From: [Nigel Stringer](#)
To: [East Pye Solar](#)
Cc: [REDACTED]
Subject: water supply
Date: 30 September 2026 10:05:36
Attachments: Screenshot 2026-09-30 at 09.03.27.png

IPR No: [REDACTED]

Response required: To confirm water supply as stated.

Document Path: C:\Users\tletendrie\Documents\ArcGIS\Projects\333101211\333101211.aprx

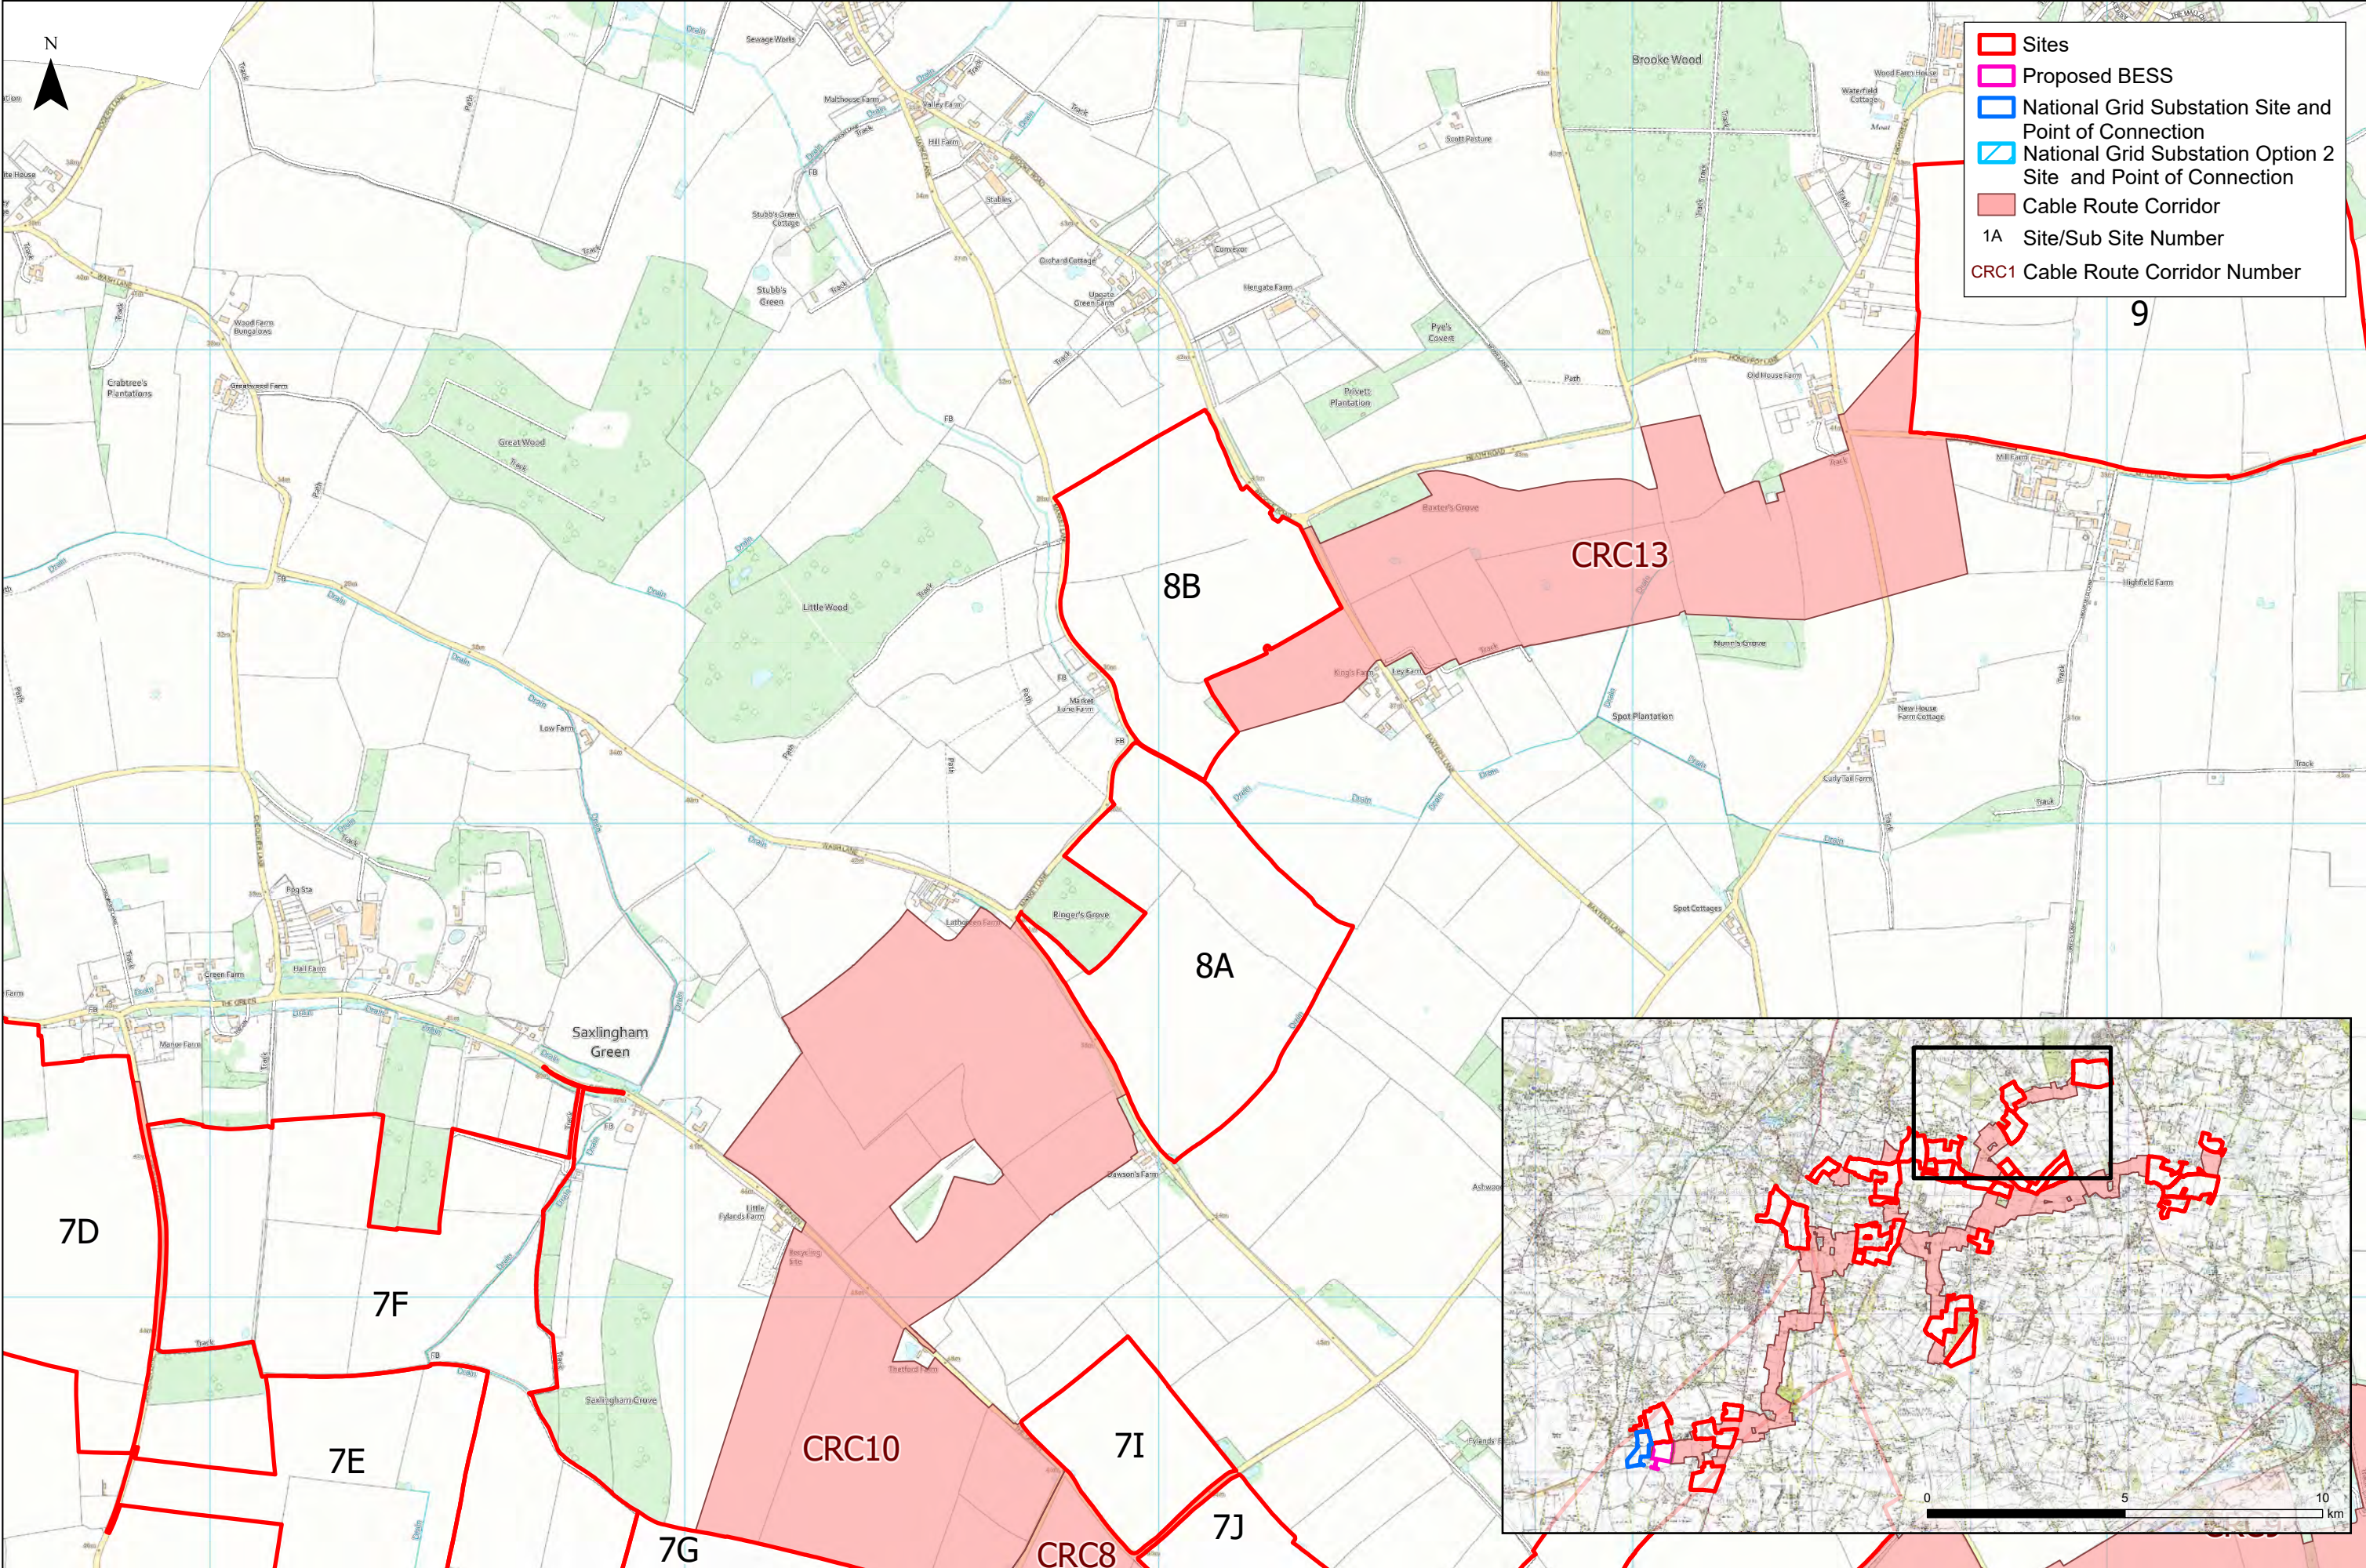
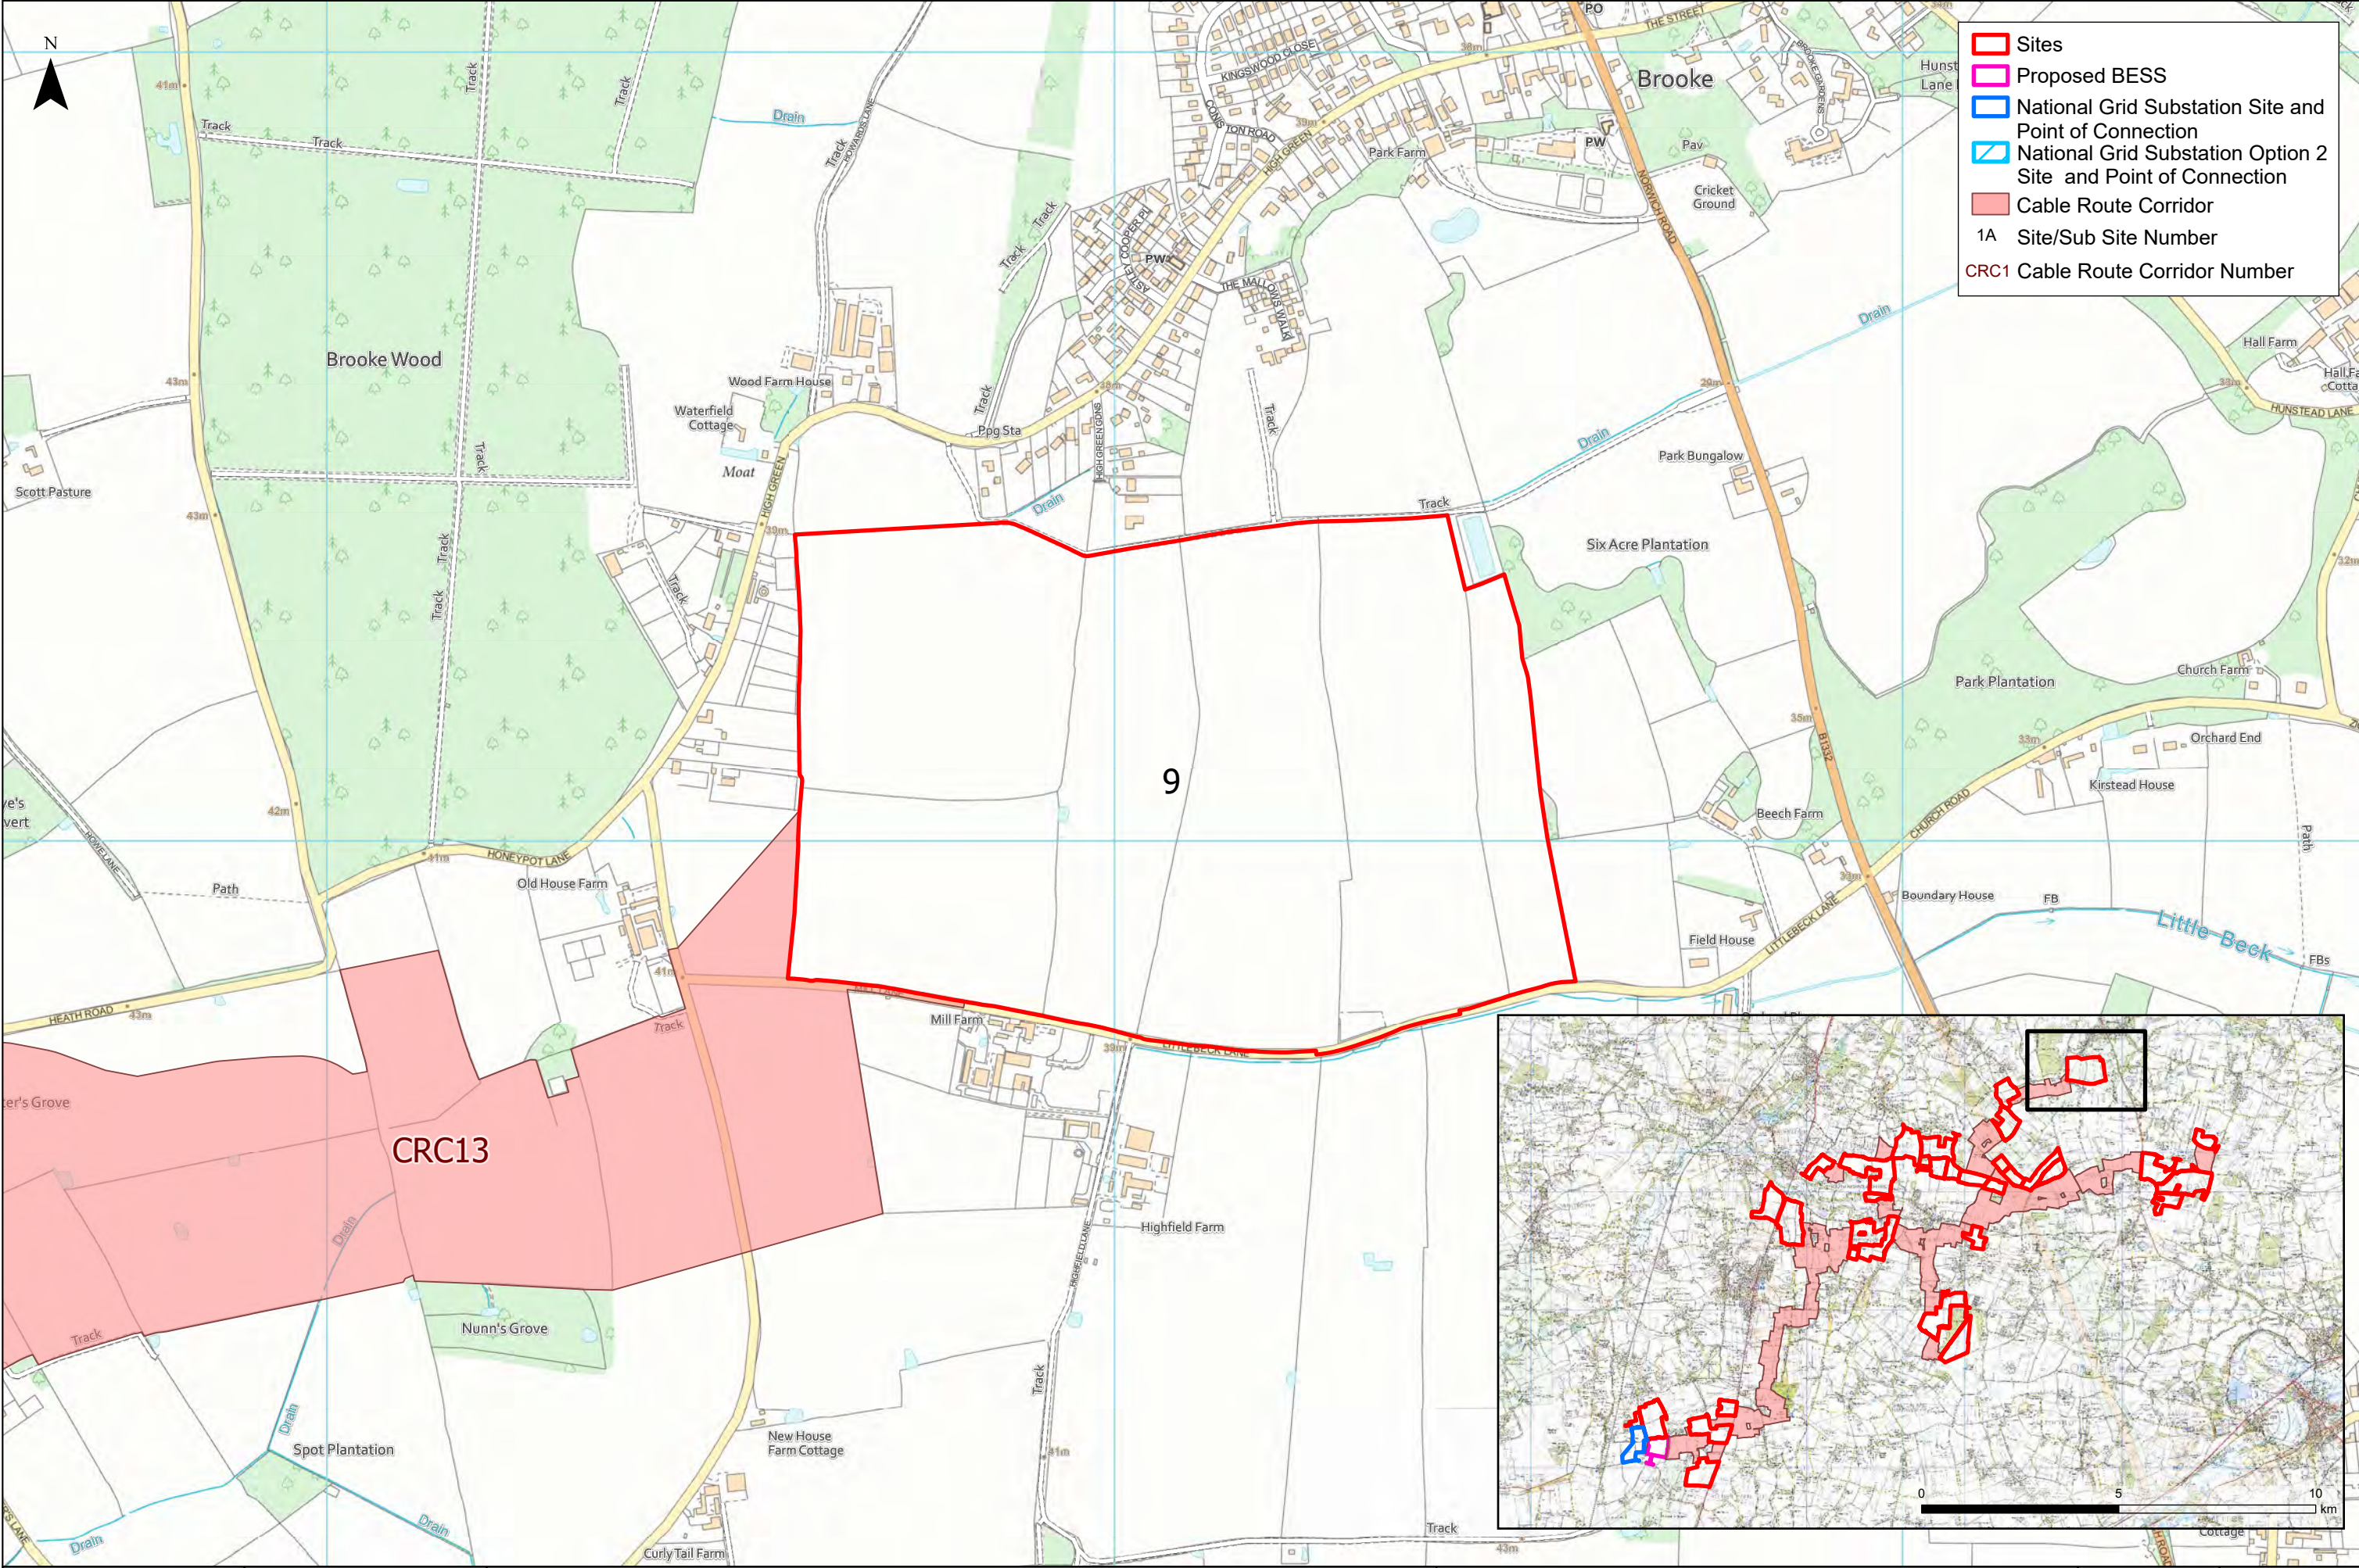
Please see attached Google map plan of site affected. The water supply to our property is a spring fed well at the rear of the house where the well pump feeds water from the ground supply to the house. The supply level water depth is between 1m and 2.5m below ground level depending on the season. It is our only water supply, we have no mains connection. Without it, we cannot live there.

Furthermore there is an ancient drainage tunnel through our grounds to the west of the house which drains water from the fields to the south of our property (Site 5) with further access points as it crosses our land and continues into the meadows to discharge onto the low lying land, the very point from where our well is fed. Any contamination of that drainage system will leach into the meadows and hence affect our well water. The water run off from site 5 will flow directly to that drain and across our land to the meadows, adjacent to our supply.

I put the Inspectorate on notice that this will be an ongoing and obvious health risk to anyone living in Boyland Hall. I have notified East Pye of this and have had no response. To avoid the possibility of any understatement or misunderstanding I state again: The proposal incurs an ongoing risk of contamination / poison to our water supply which is obvious. The water run off from Site 5 will include residue from construction activities and ongoing maintenance for the foreseeable future, eg washing of solar panels. The slope of the landscape dictates that all of that water will drain into the tunnel and across our land.
